I refer to our meeting on site last week and SCC's most recent letter dated 20 February 2017.

I provide additional comments and response to the SCC submission.

Issued Raised in SCC letter dated 20/2/17

TYPICAL 5m ROAD 01 CROSS SECTION
SCALE 1:50

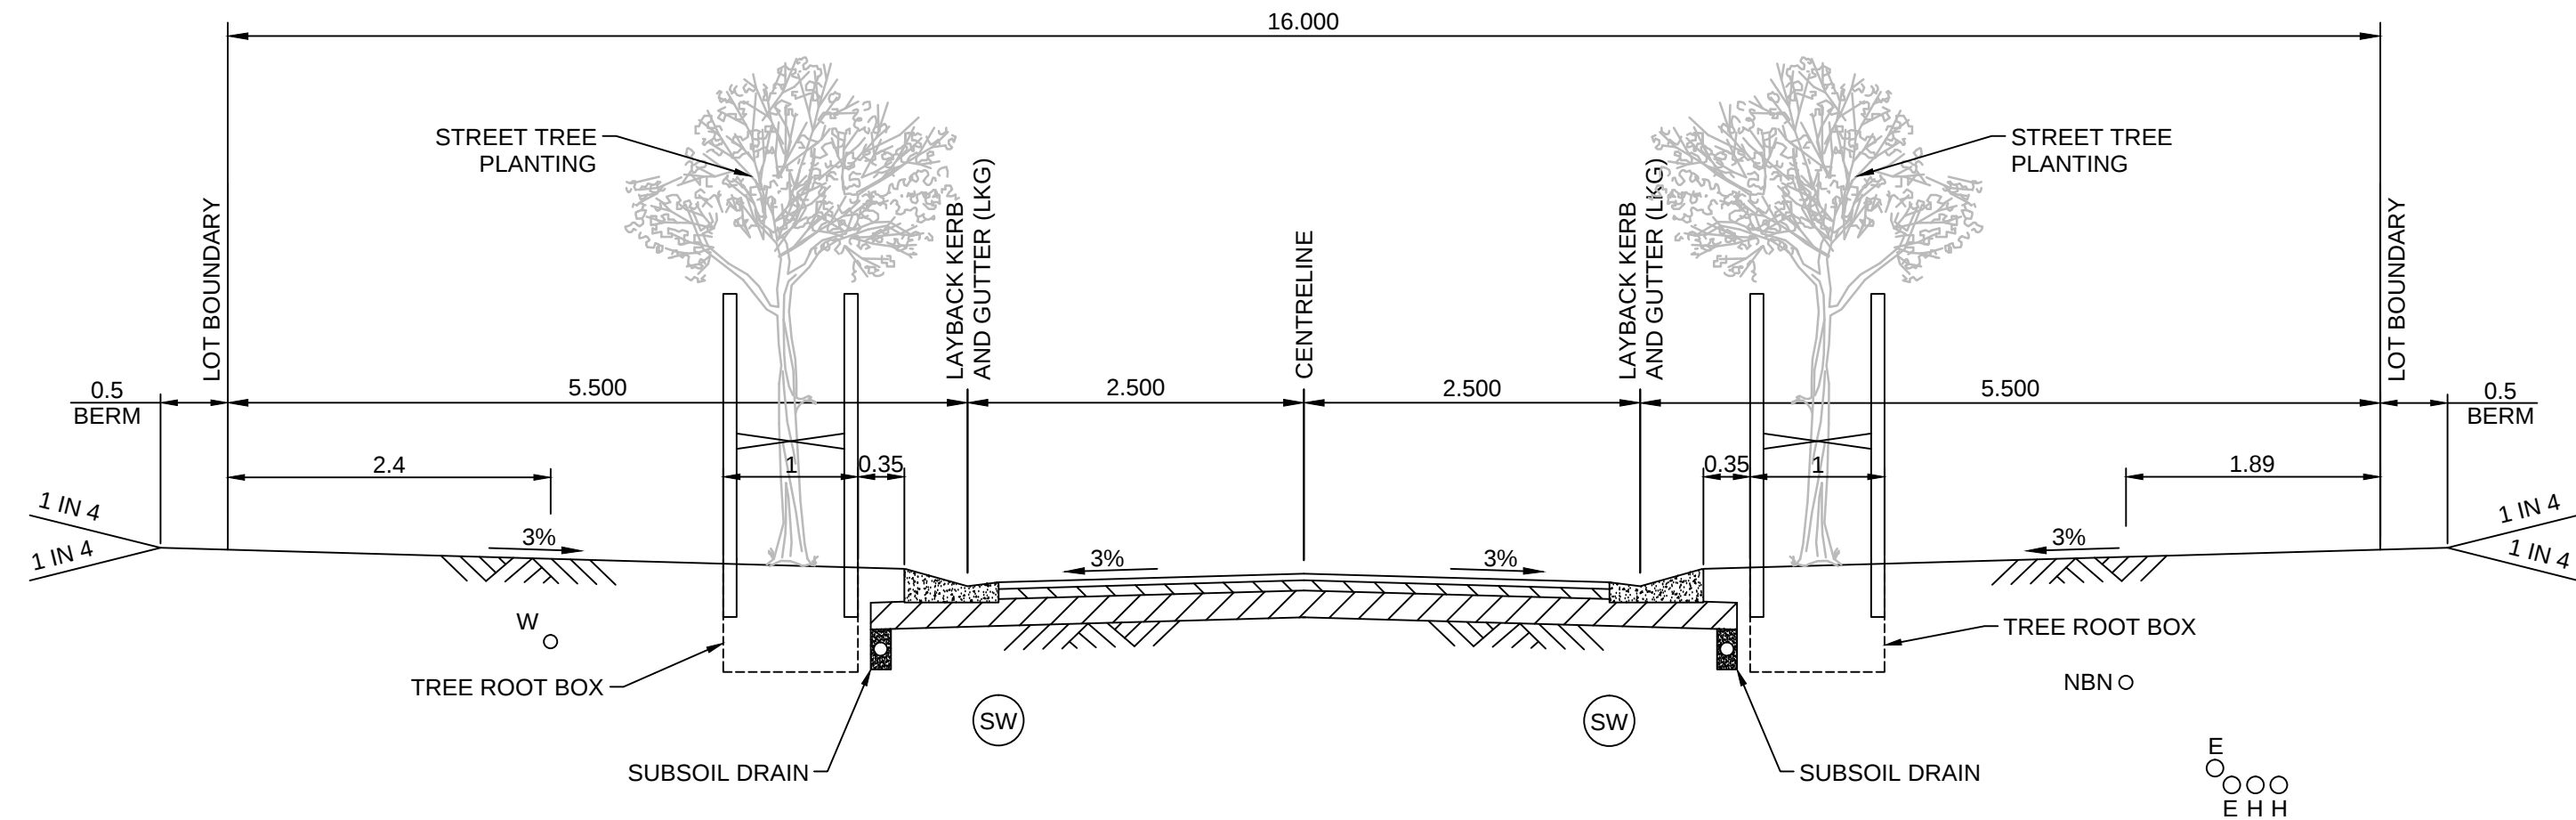
Pavement widths in the existing consent document stipulate 5m width required – no change to this requirement is requested. SCC notes that the adjoining land to the south has 6m wide roads. This is not factual. I note at our site meeting the 5m carriageway width was paced out personally by myself. I also attach the subdivision document as Appendix 5A for land to the south with condition 7 requiring a 5m wide carriageway. I also attach as Appendix 10 the approved Construction Certificate drawings for the development to the south stamped by SCC on 1/7/15 which certifies 5m wide carriageways. The reasons outlined by SCC are interesting but irrelevant as to why this road width is not suitable. SCC approved 5m carriageways next door and DPE approved 5m carriageways on this site. You will also note on Appendix 8 that road reserve widths are 16m wide as per the DCP requirements.

Further, verge widths also comply with Shoalhaven DCP2014 Chapter G11 Table 3 (see Appendix 9 attached) which require 4m (min) verge widths. Verge widths will be approximately 5.5m wide (16m road reserve less 5m pavement = 2 x 5.5m verges.)

PROPOSED RESIDENTIAL SUBDIVISION

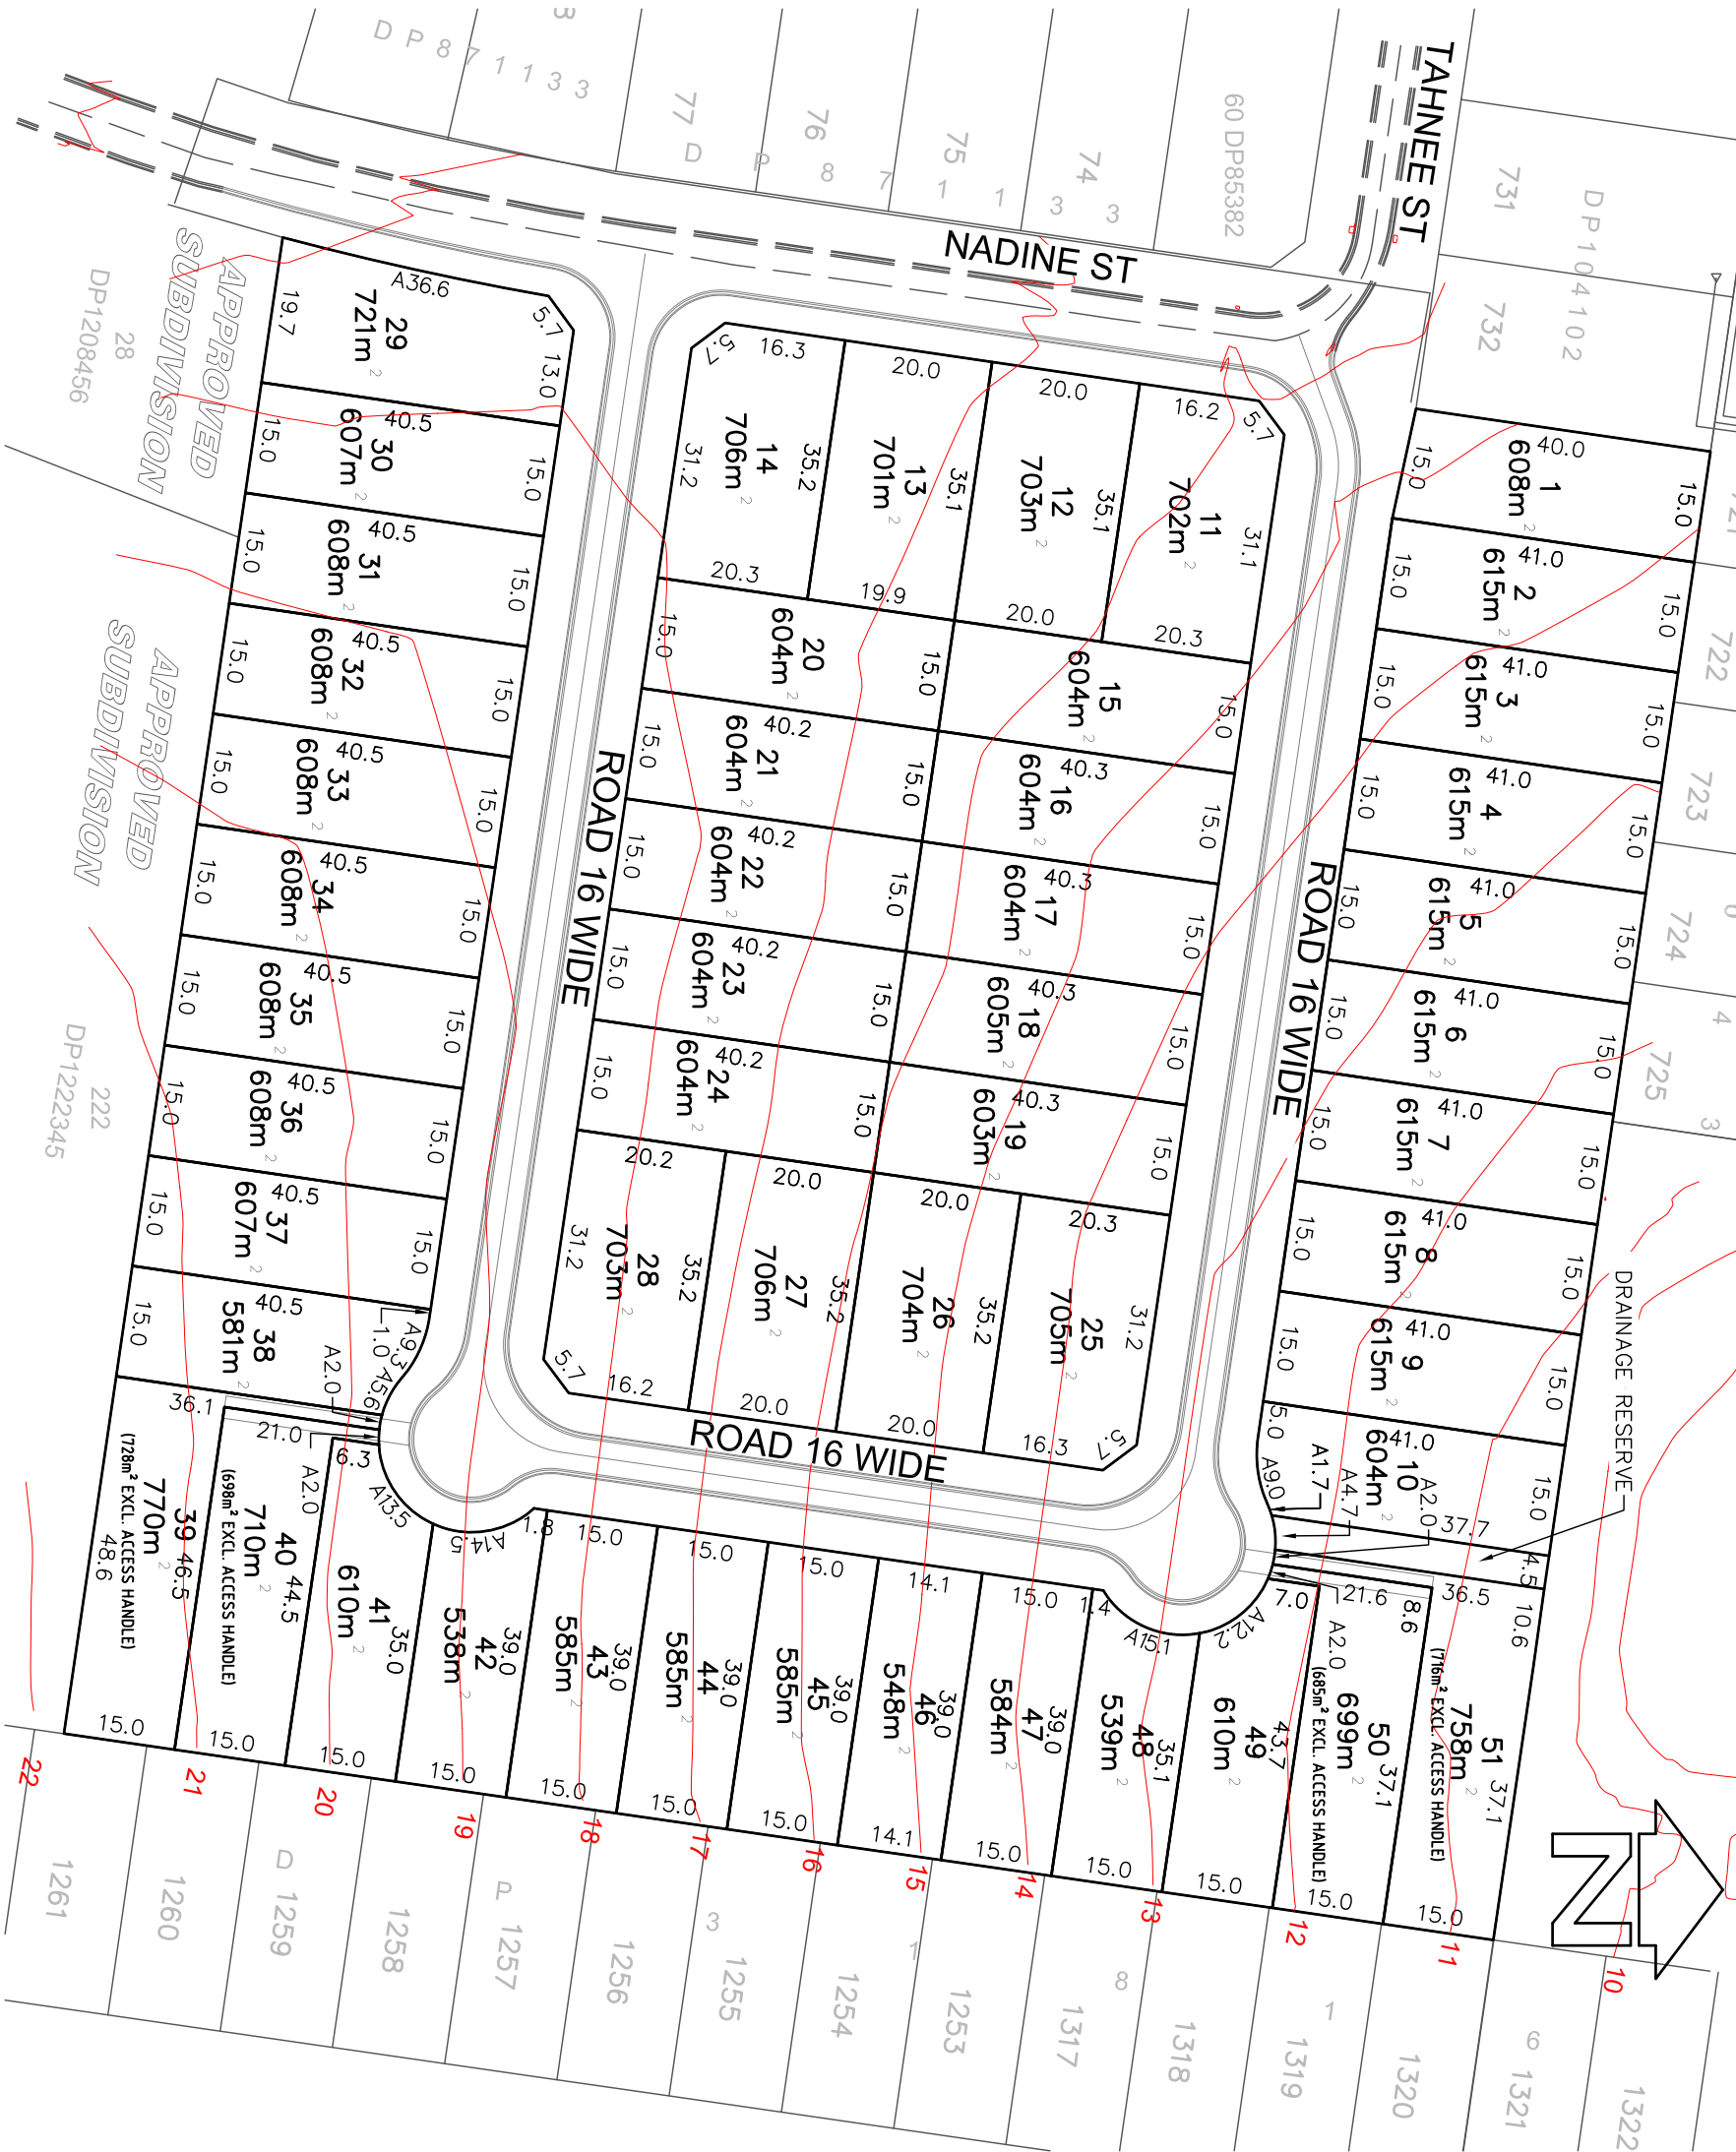
Lot Layout

Appendix 6 attached shows multiple lots that are 15.24m wide approved by SCC on the adjoining land to the east.

Appendix 8 shows multiple lots that are 15m wide approved by SCC in only August 2016(see stage 11 for 15m wide east-west allotments). I have attached both the scanned SCC stamped drawing and a clearer unstamped original of the same drawing for clarity.

It is very clear from the "Solar Access for Lots Guide" for NSW Subdivisions submitted with our previous submission that 15m wide lots on a north facing slope have sufficient space to contain the required solar access zones as previously outlined.
